Approval of details reserved by condition imposed under ref Y/5/17/OUT relating to Condition Nos 11 - drainage strategy, 12 - protect existing public sewer, 13 - surface water drainage scheme, 15 - SuDs system and 30 - 10% energy supply from decentralised & renewable sources.

Cinders Lane Nursery And Works To The Rear Cinders Lane Yapton BN18 0JJ

Condition Number 12

Decision:

**Engineering Details
Drainage Layout**

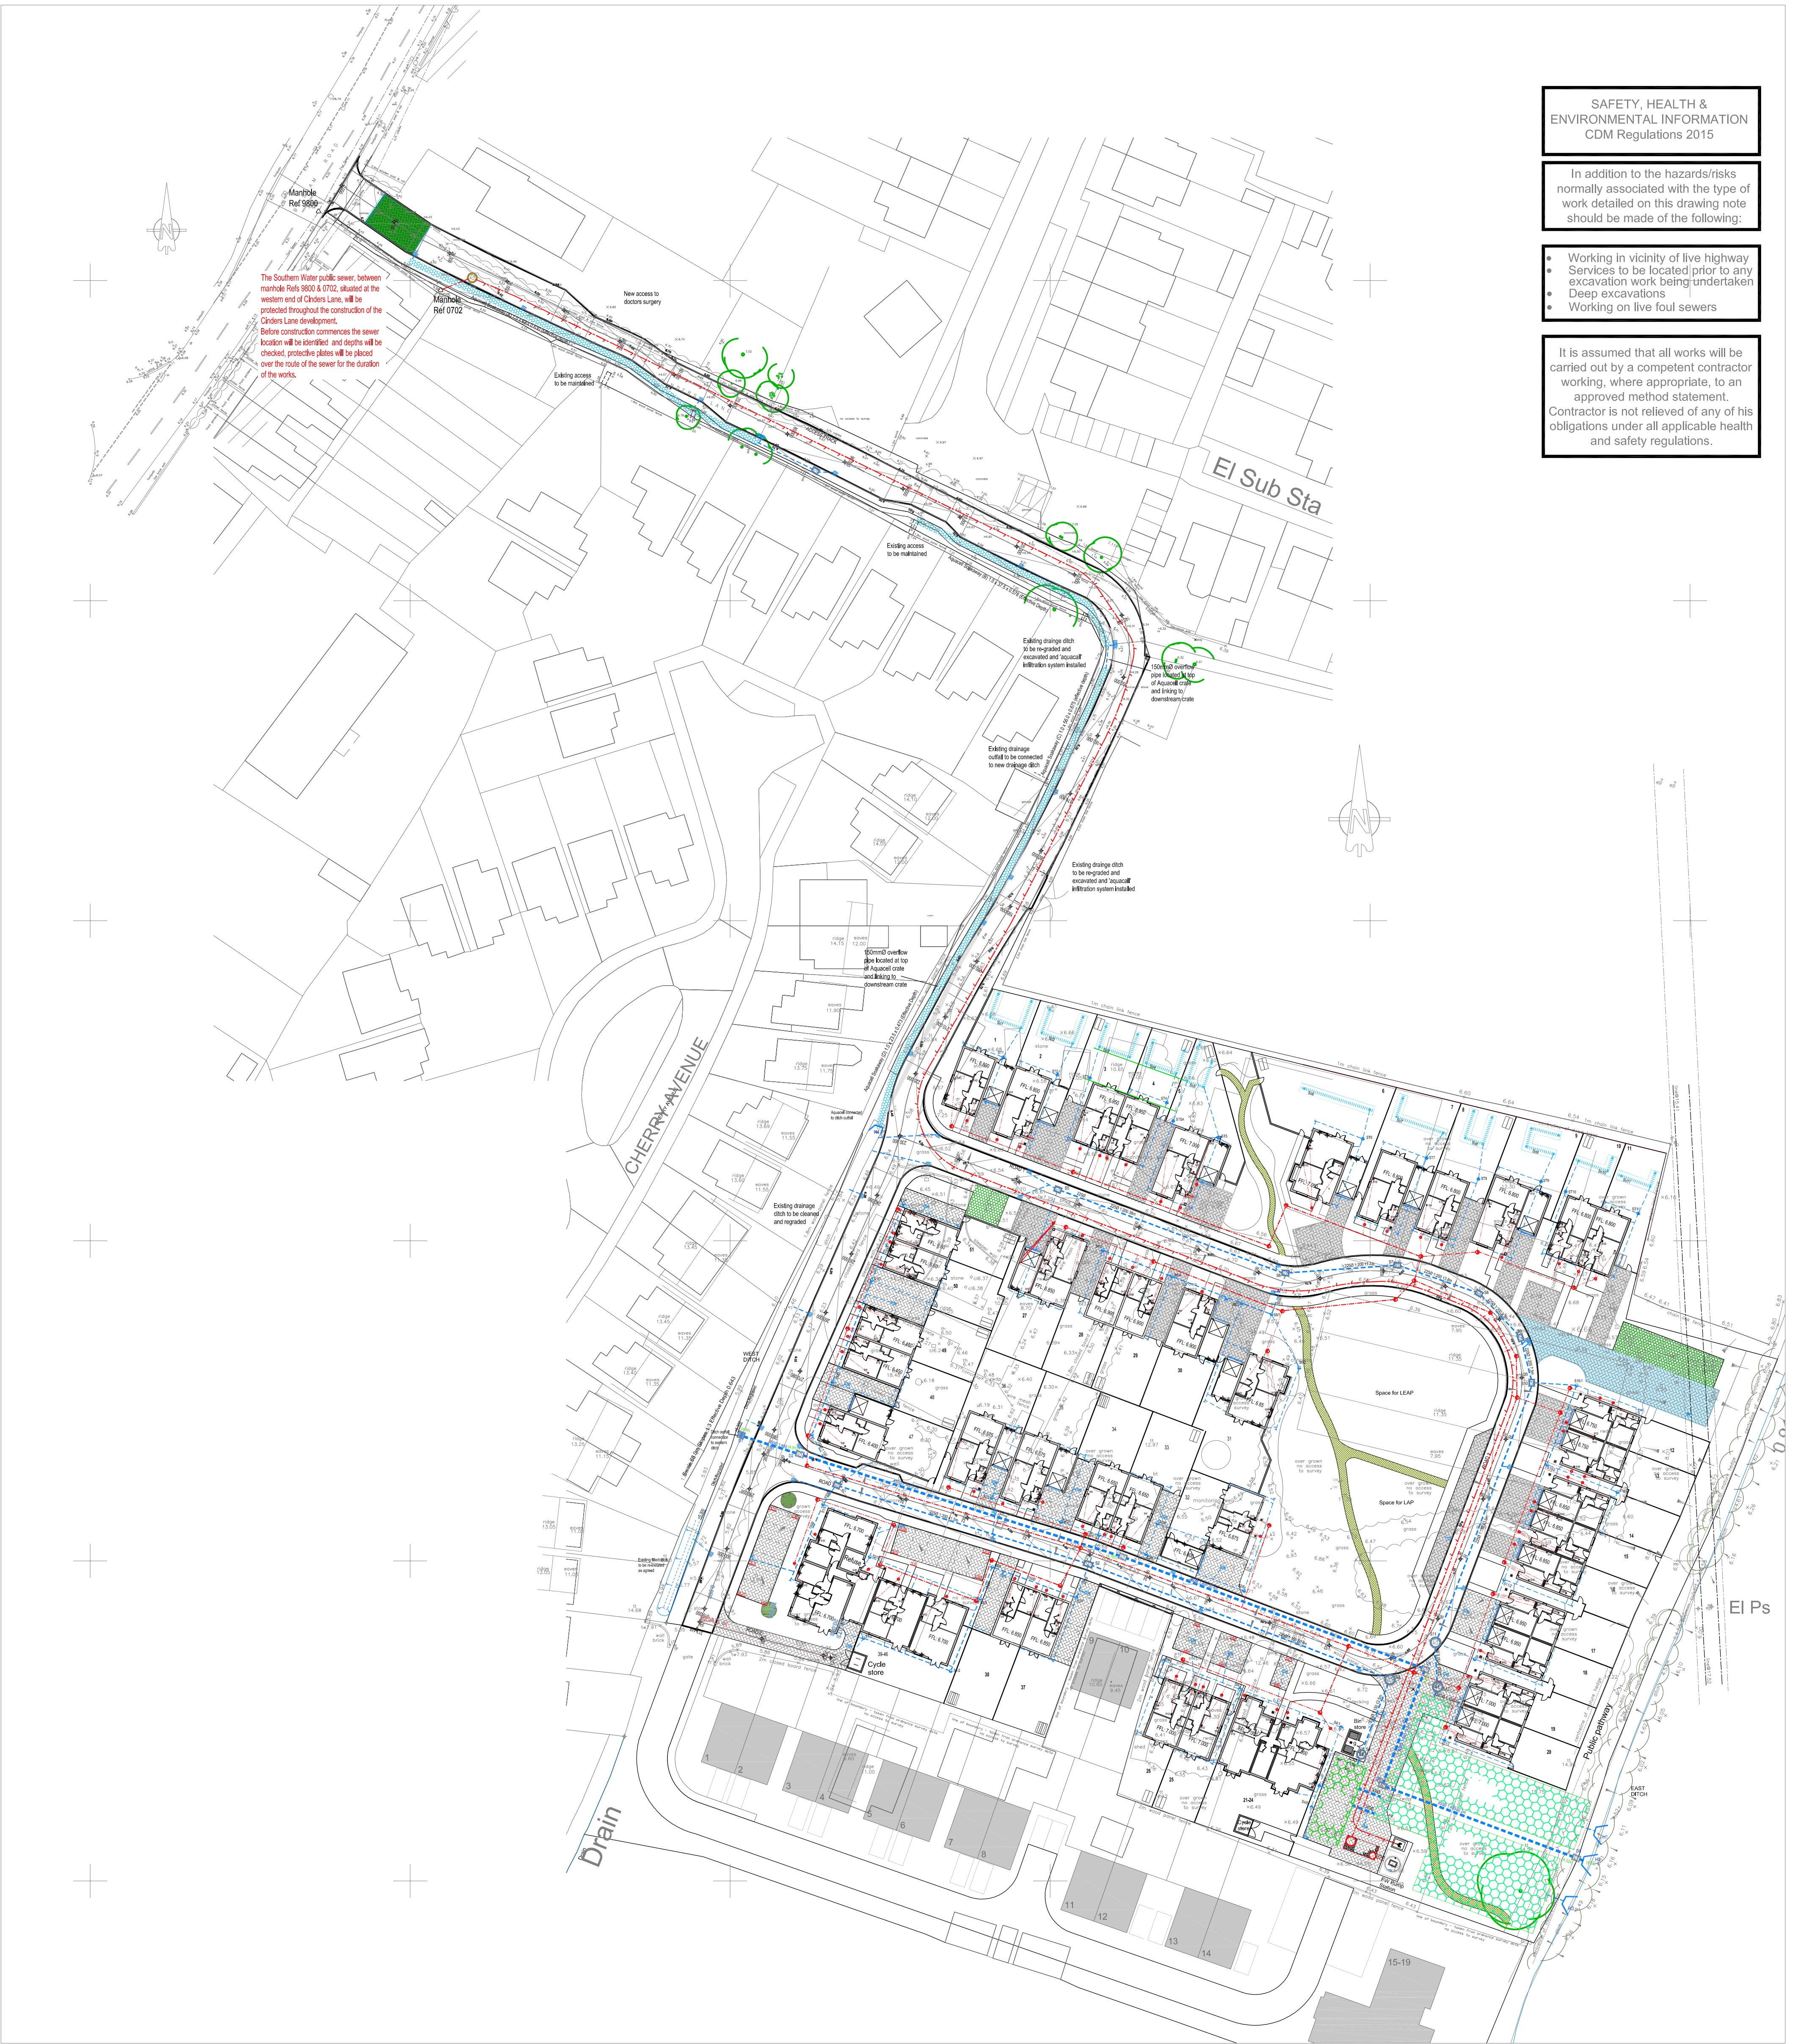
Drawing 502-03 Rev A "Engineering Details Drainage Layout" shows how the existing sewer will be protected. In the absence of any continued objection from Southern Water, it is considered that the details are acceptable and therefore, the condition can be discharged on the understanding that the sewer will be protected in accordance with the agreed scheme.
